Application for modification of planning obligation dated 22nd March 2012 under planning application reference LU/355/10 relating to the Schedule 1 exemption clause & Schedule 2 triggers & locations of LEAP/NEAP
Land at Courtwick Littlehampton

Thank you for your internet comments made on 16th October 2018 which has been recorded as **'no objection'** with the comments as follows:

PLAN OF CENTRAL SQUARE 1:200

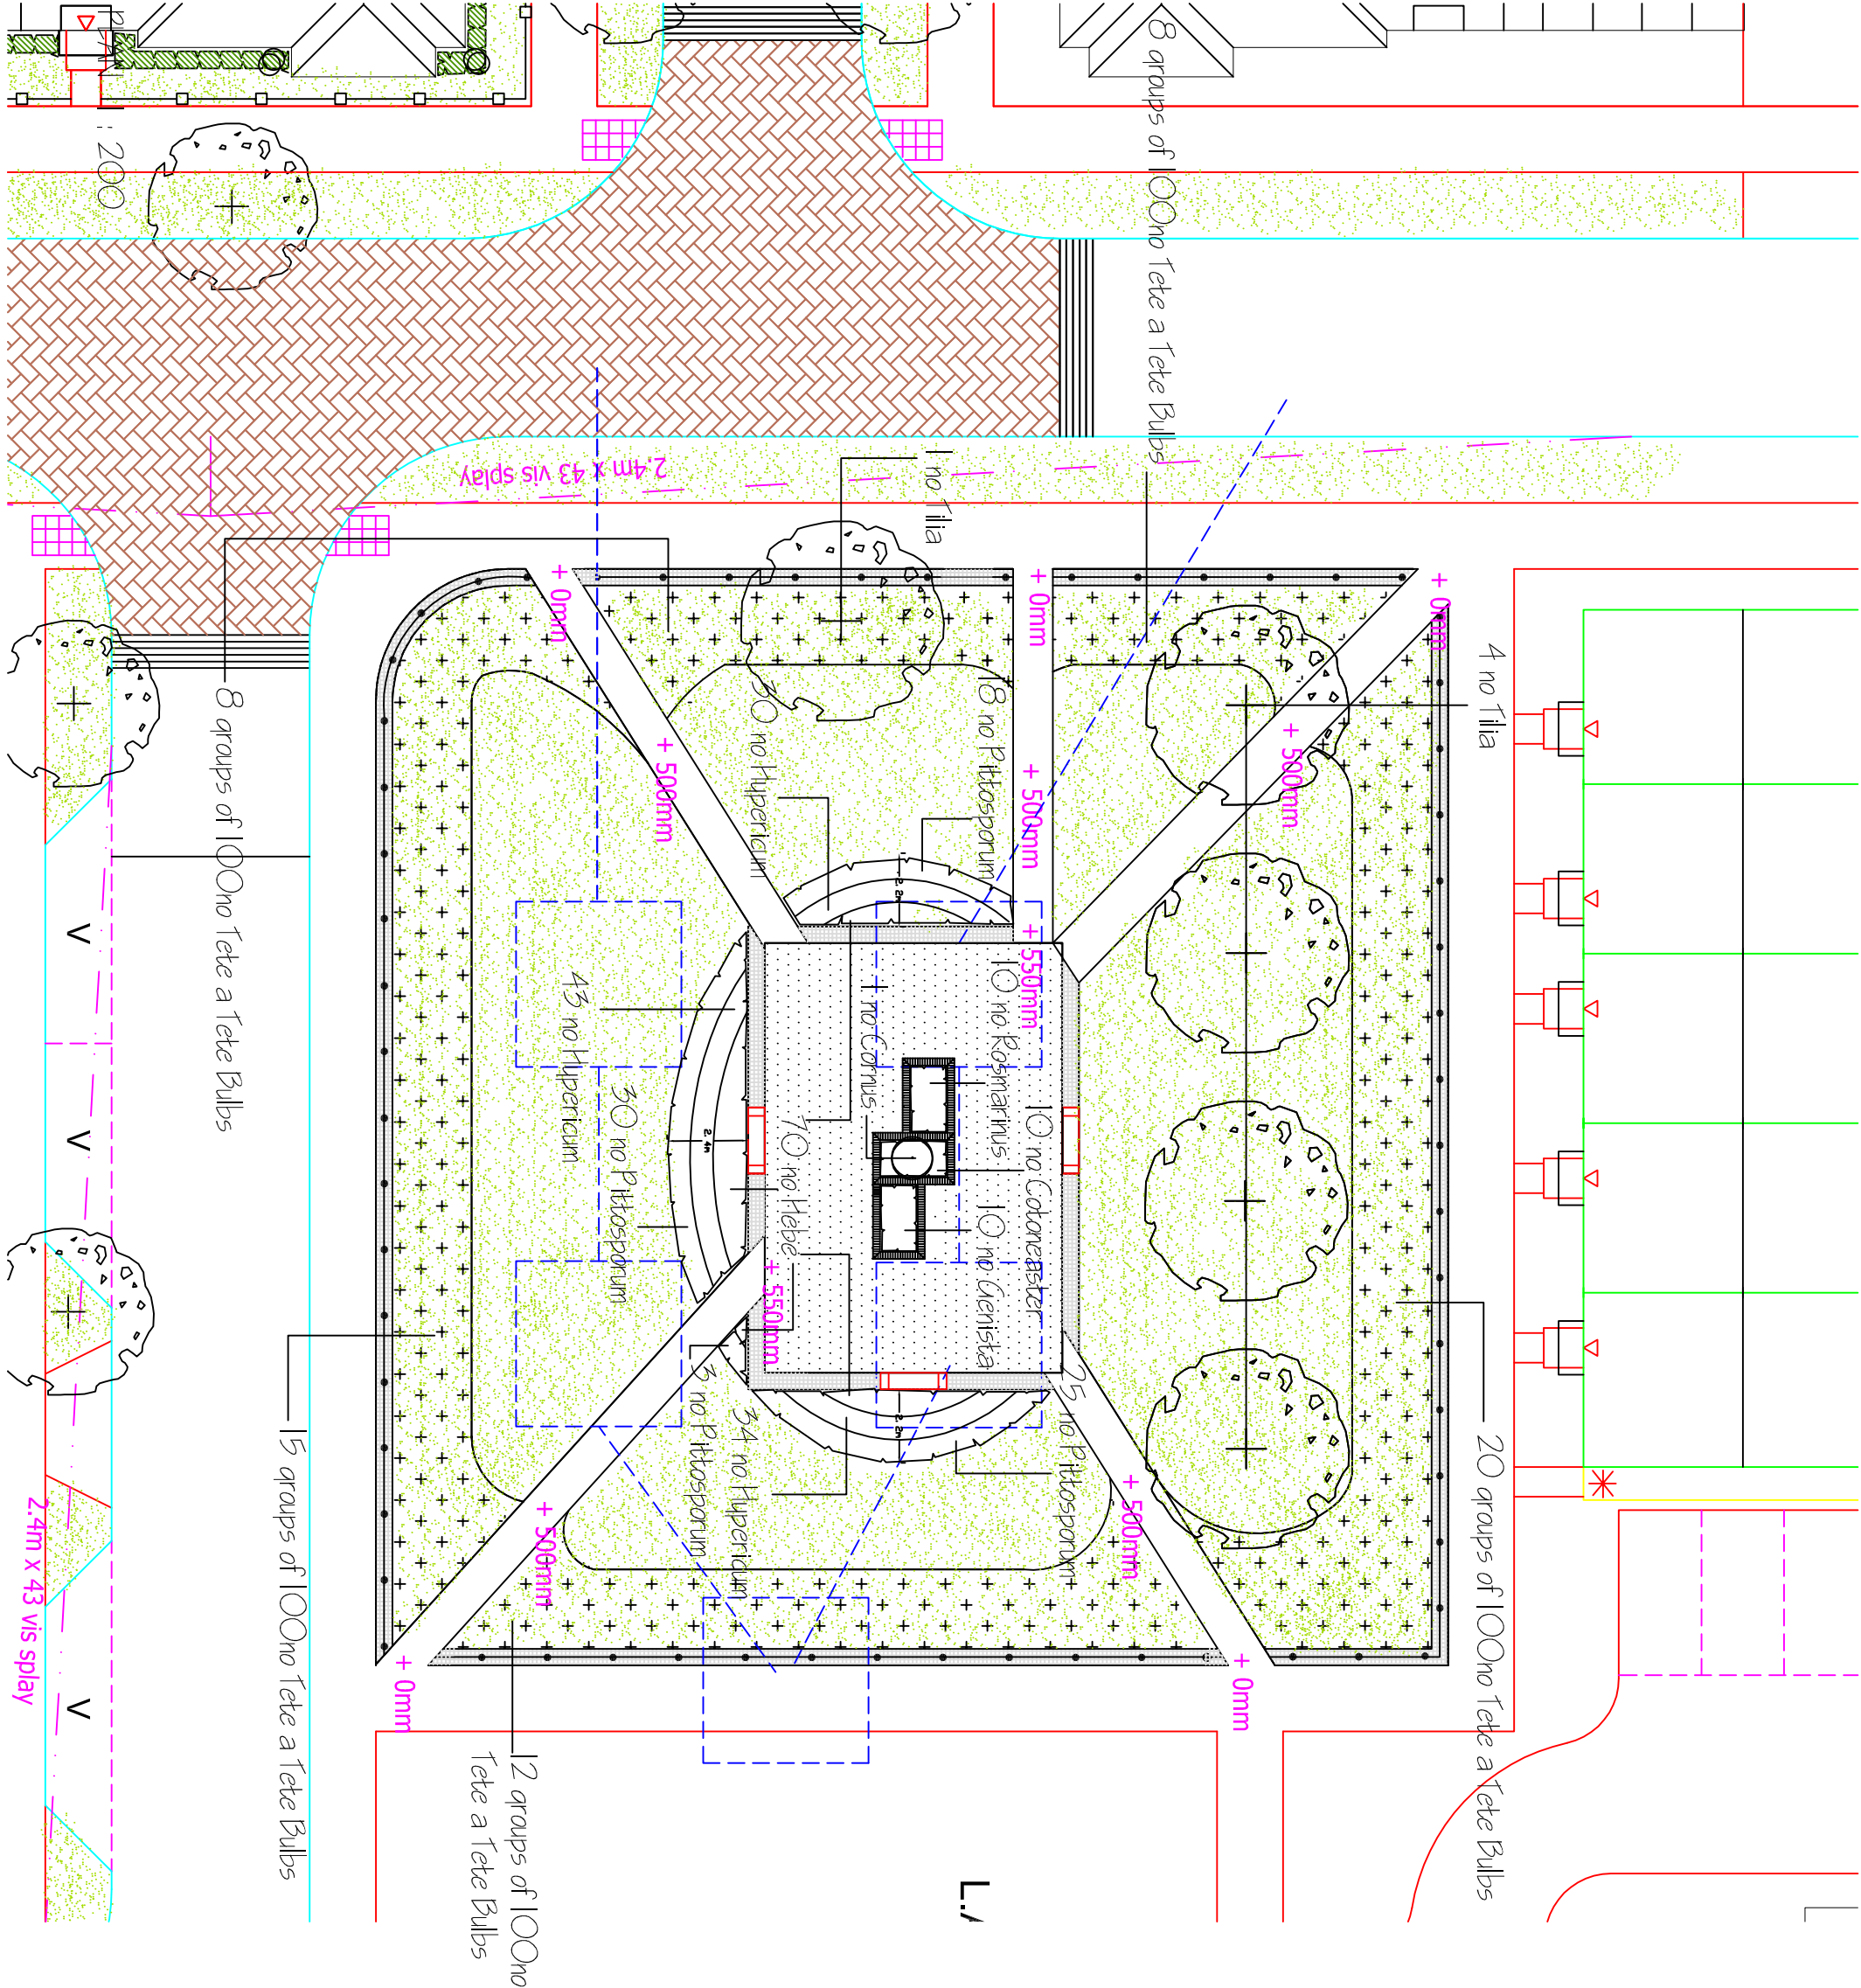
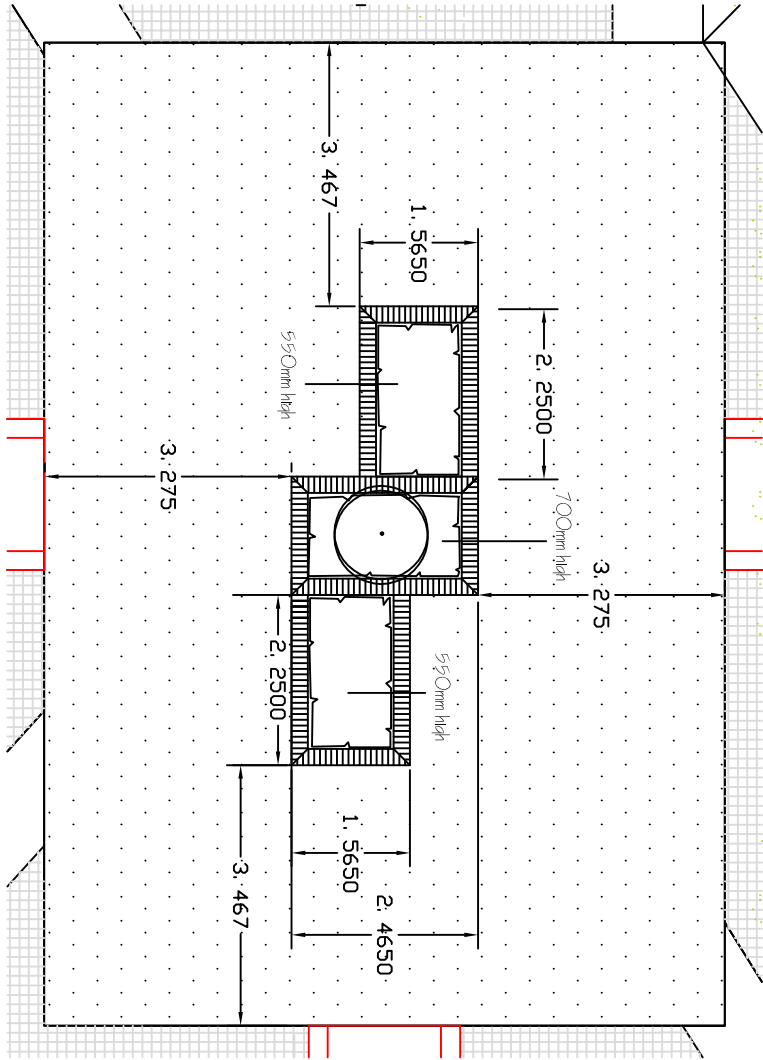
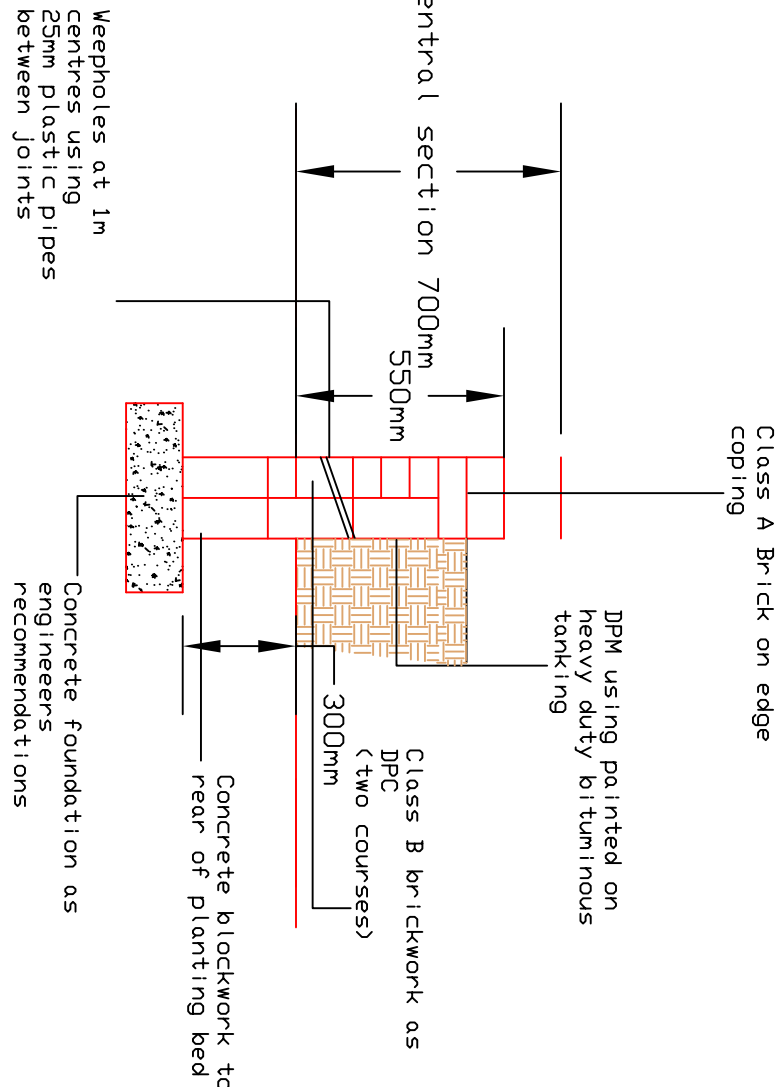
The Town Council's Planning and Transportation Committee considered this matter at its meeting held on Monday 15th October 2018 and had no objection to the application. Observing the lack of any explanation for the proposed change to the central area, concern about the impact on the community of the loss of the play area as an amenity facility was expressed. In particular, there was concern that the introduction of vegetation could encourage Anti-Social Behaviour.
